9 Thornton Road  
Little Heath  
Herts  
EN6 1JJ

30th April 2018

**Planning Application: 7 Thornton Road, EN6 1JJ – reference: 6/2018/0803/HOUSE**

Proposed Ground Floor Plan

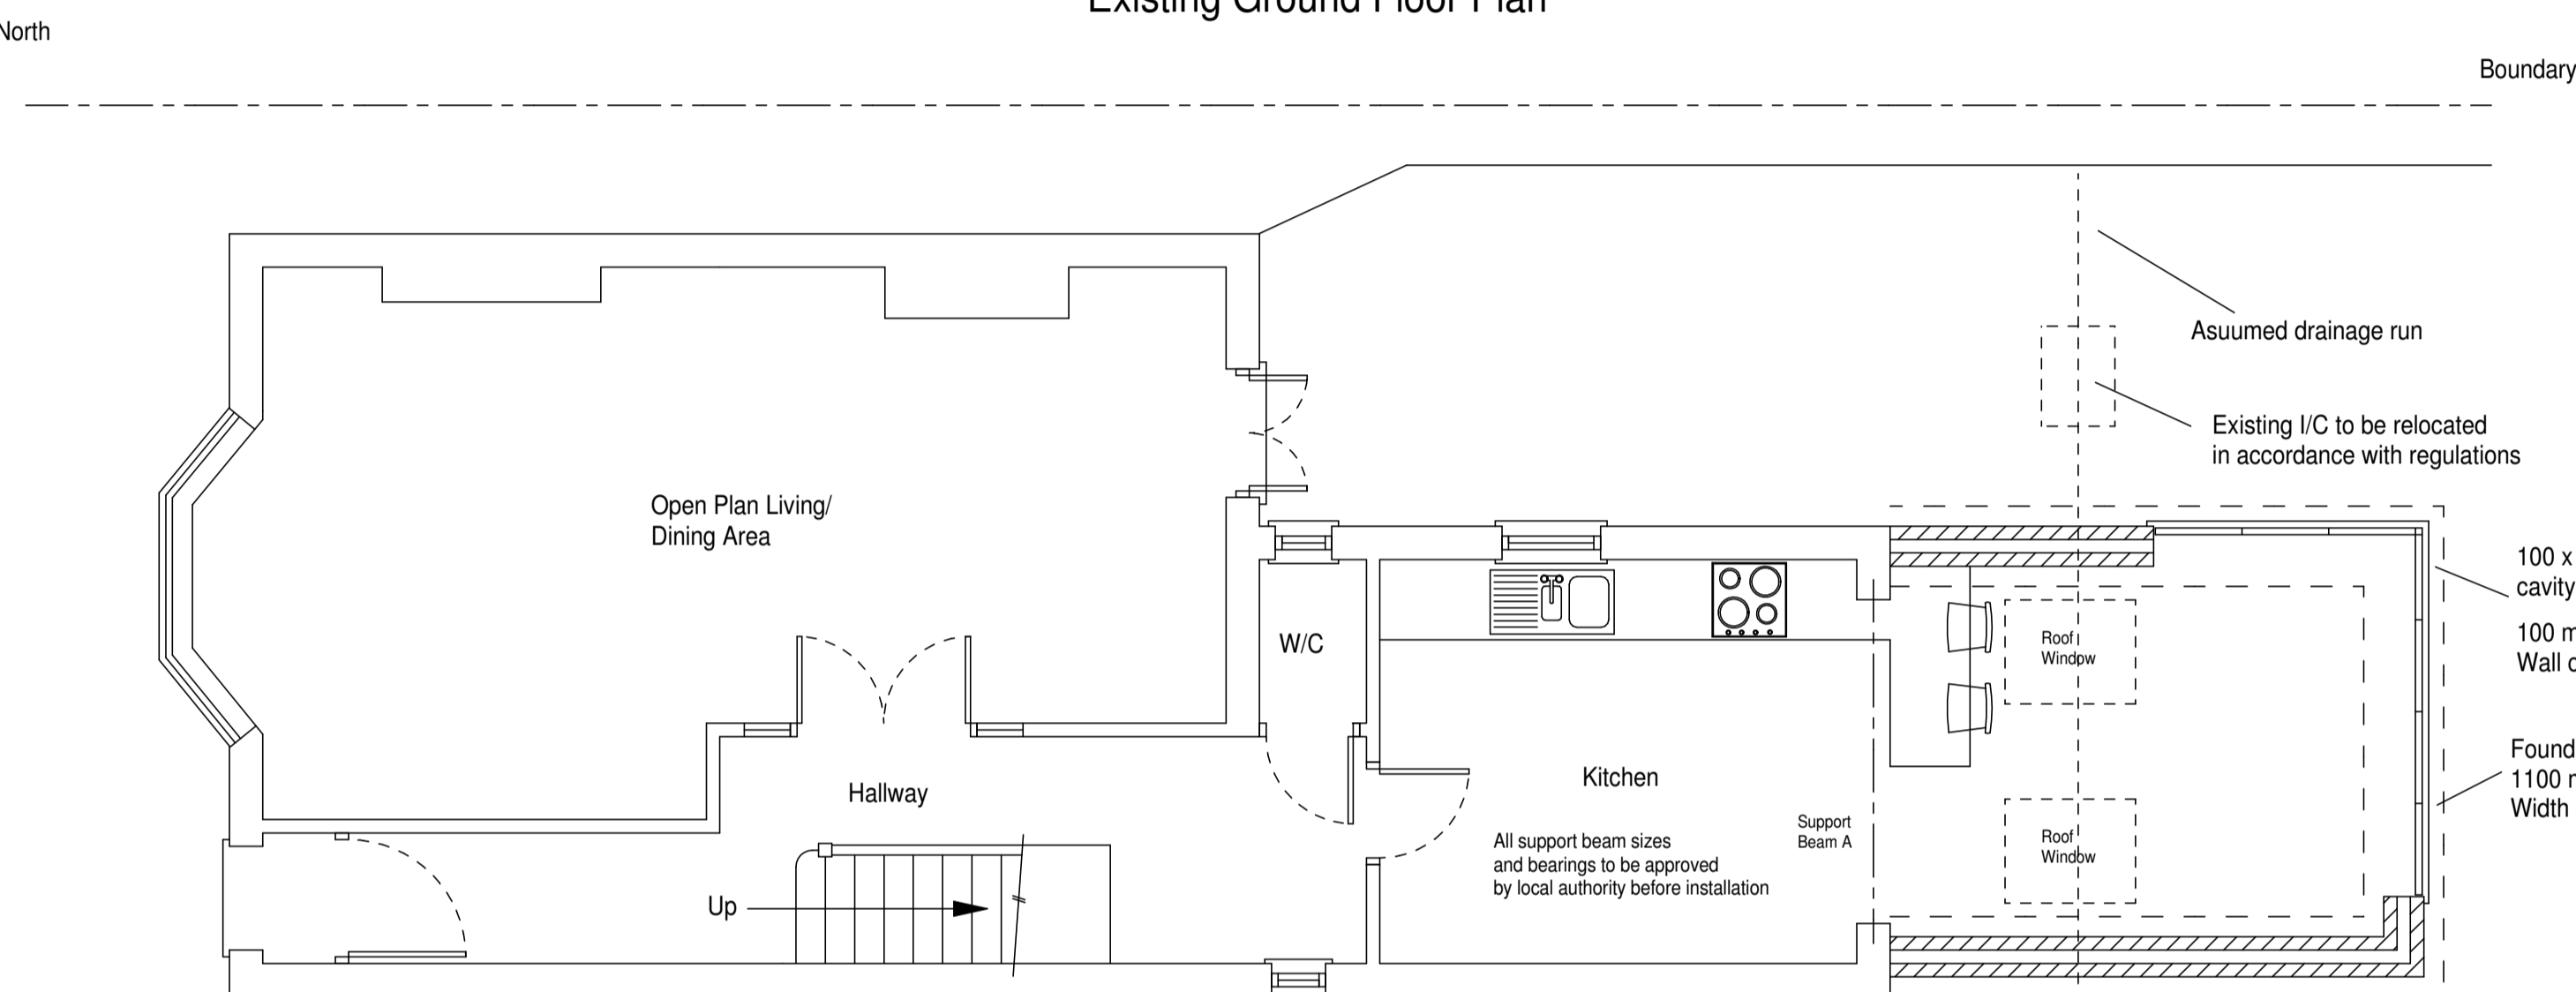
I note the design of the proposed extension includes a step back from the boundary line; this is presumably in order to address the incorrect positioning of the existing fence, and in order to ensure guttering for the new room will not extend to trespass over my own property (as it clearly does at present). If you are minded to approve this Application, perhaps these two matters could also be conditioned.

Proposed Rear Elevation

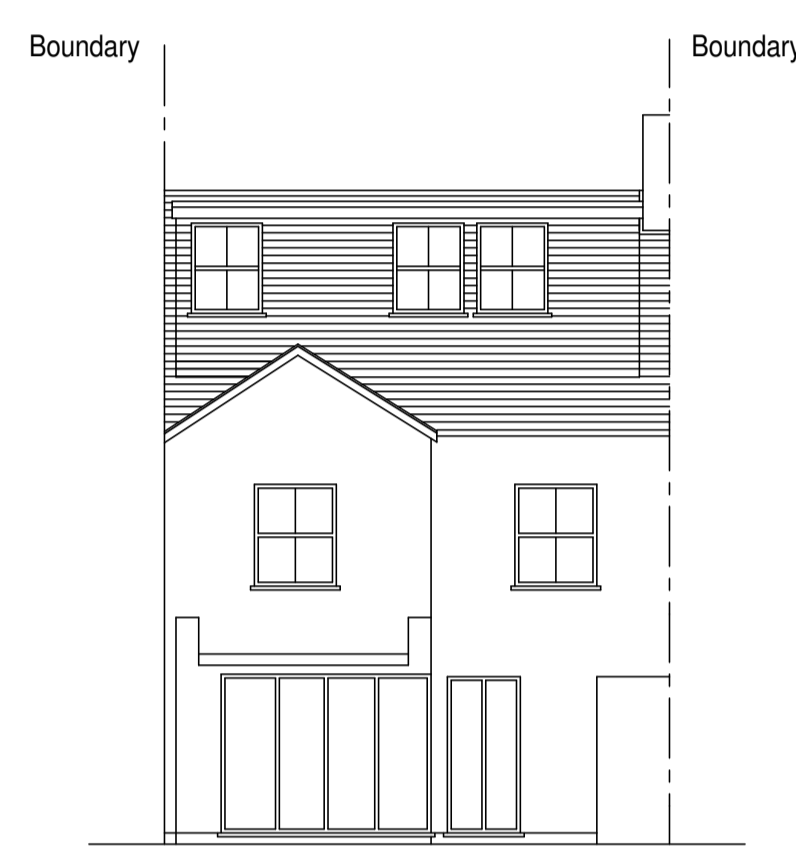
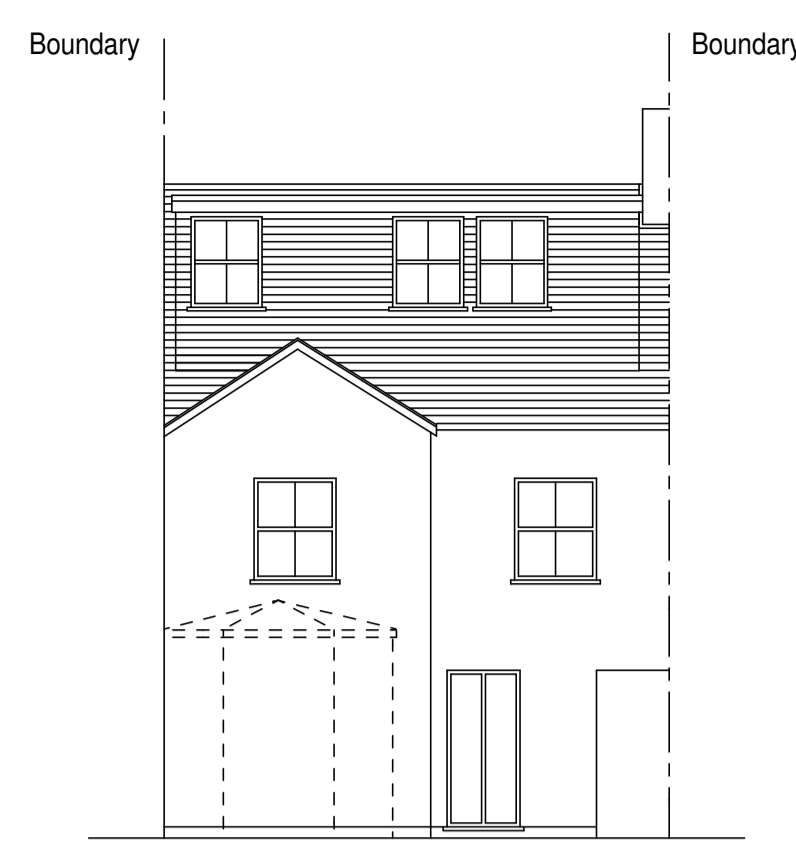
For the avoidance of doubt, if the application is granted, I would ask the Authority to ensure all height dimensions are agreed and written on the drawings, and also that the bricks used match both the bonding style and colour of the existing building, the latter perhaps by using old recycled stocks. My sincere hope is that the invariably ugly red brick engineering plinths can be avoided, and I would also ask that any plinth facing my house is fully rendered – I'm hoping this will also serve as an opportunity to replace the crumbling rendering on the existing plinths.

Proposed Side Elevation

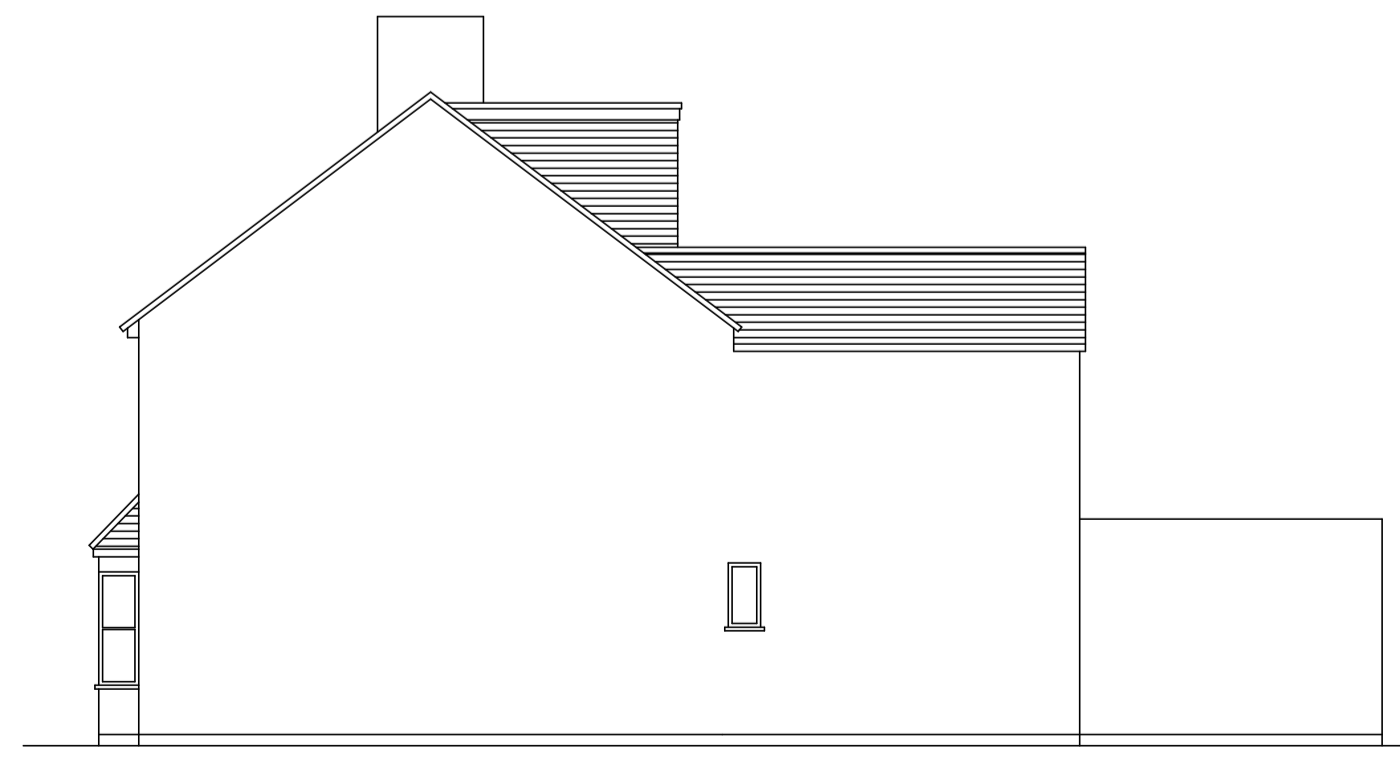
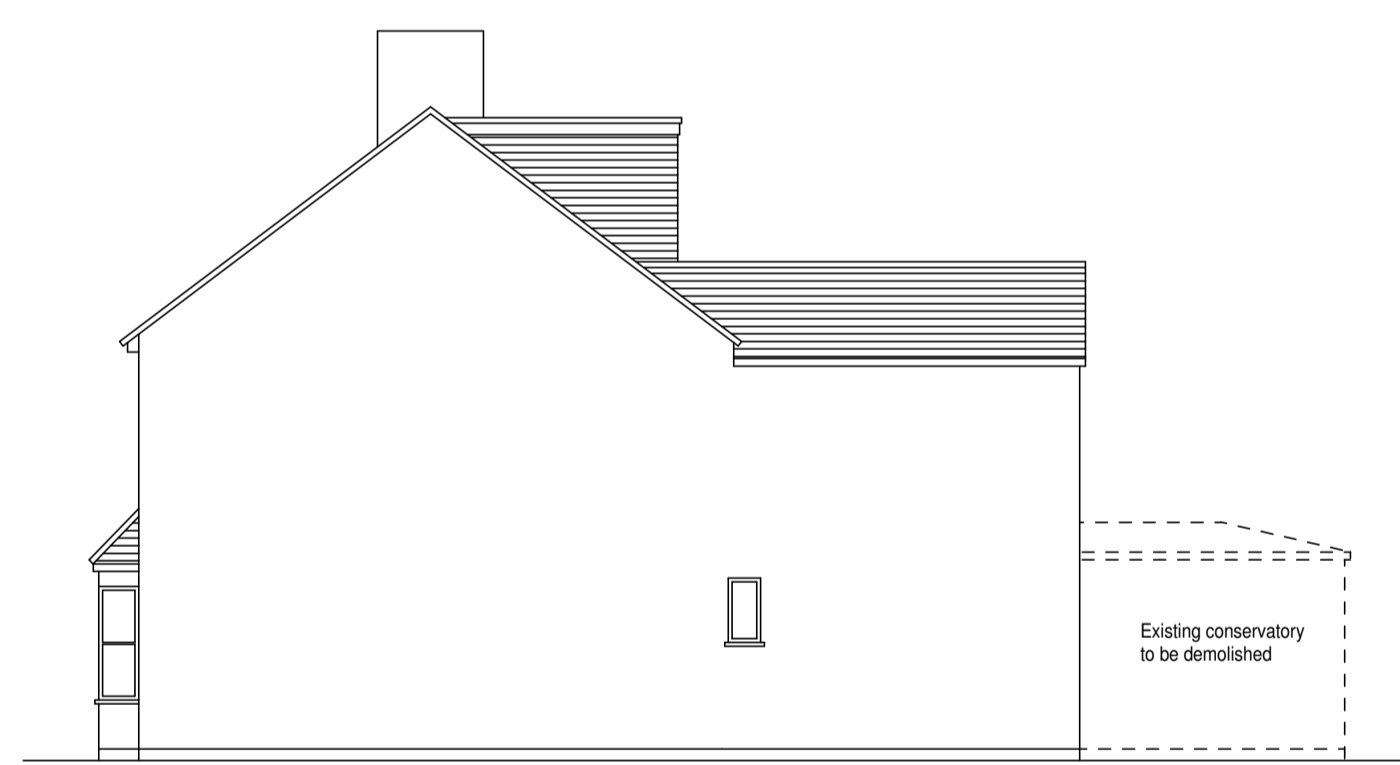
Dealing firstly with the rear extension itself; I have to say I am very concerned about the 4m long, 3m high flat roof brick-walled extension, as it replaces a more modest glass conservatory building which has a pitched roof with eaves at 2.5m with a ridge at 3m. The existing extension to number 7 already dominates my garden, and the proposed further new wall will only make matters worse. If the eaves could be slightly lower, or preferably the flat roof be replaced with a pitched roof matching the rest of the house, then the proposed extension will not so obviously dominate my garden.

The existing conservatory eaves are at 2.5m for 3m long, but the proposal suggests a new wall 3m high and 4m long. If the application is granted, I would very much prefer to keep the eaves at the same position, in other words no higher than 2.4/2.5m; reducing the wall from 4m to 3m long would also result in a far less intrusive structure. In terms of scale and massing, a more modest addition to my neighbour's house (as suggested herein) would be less visually imposing and therefore eminently preferable.
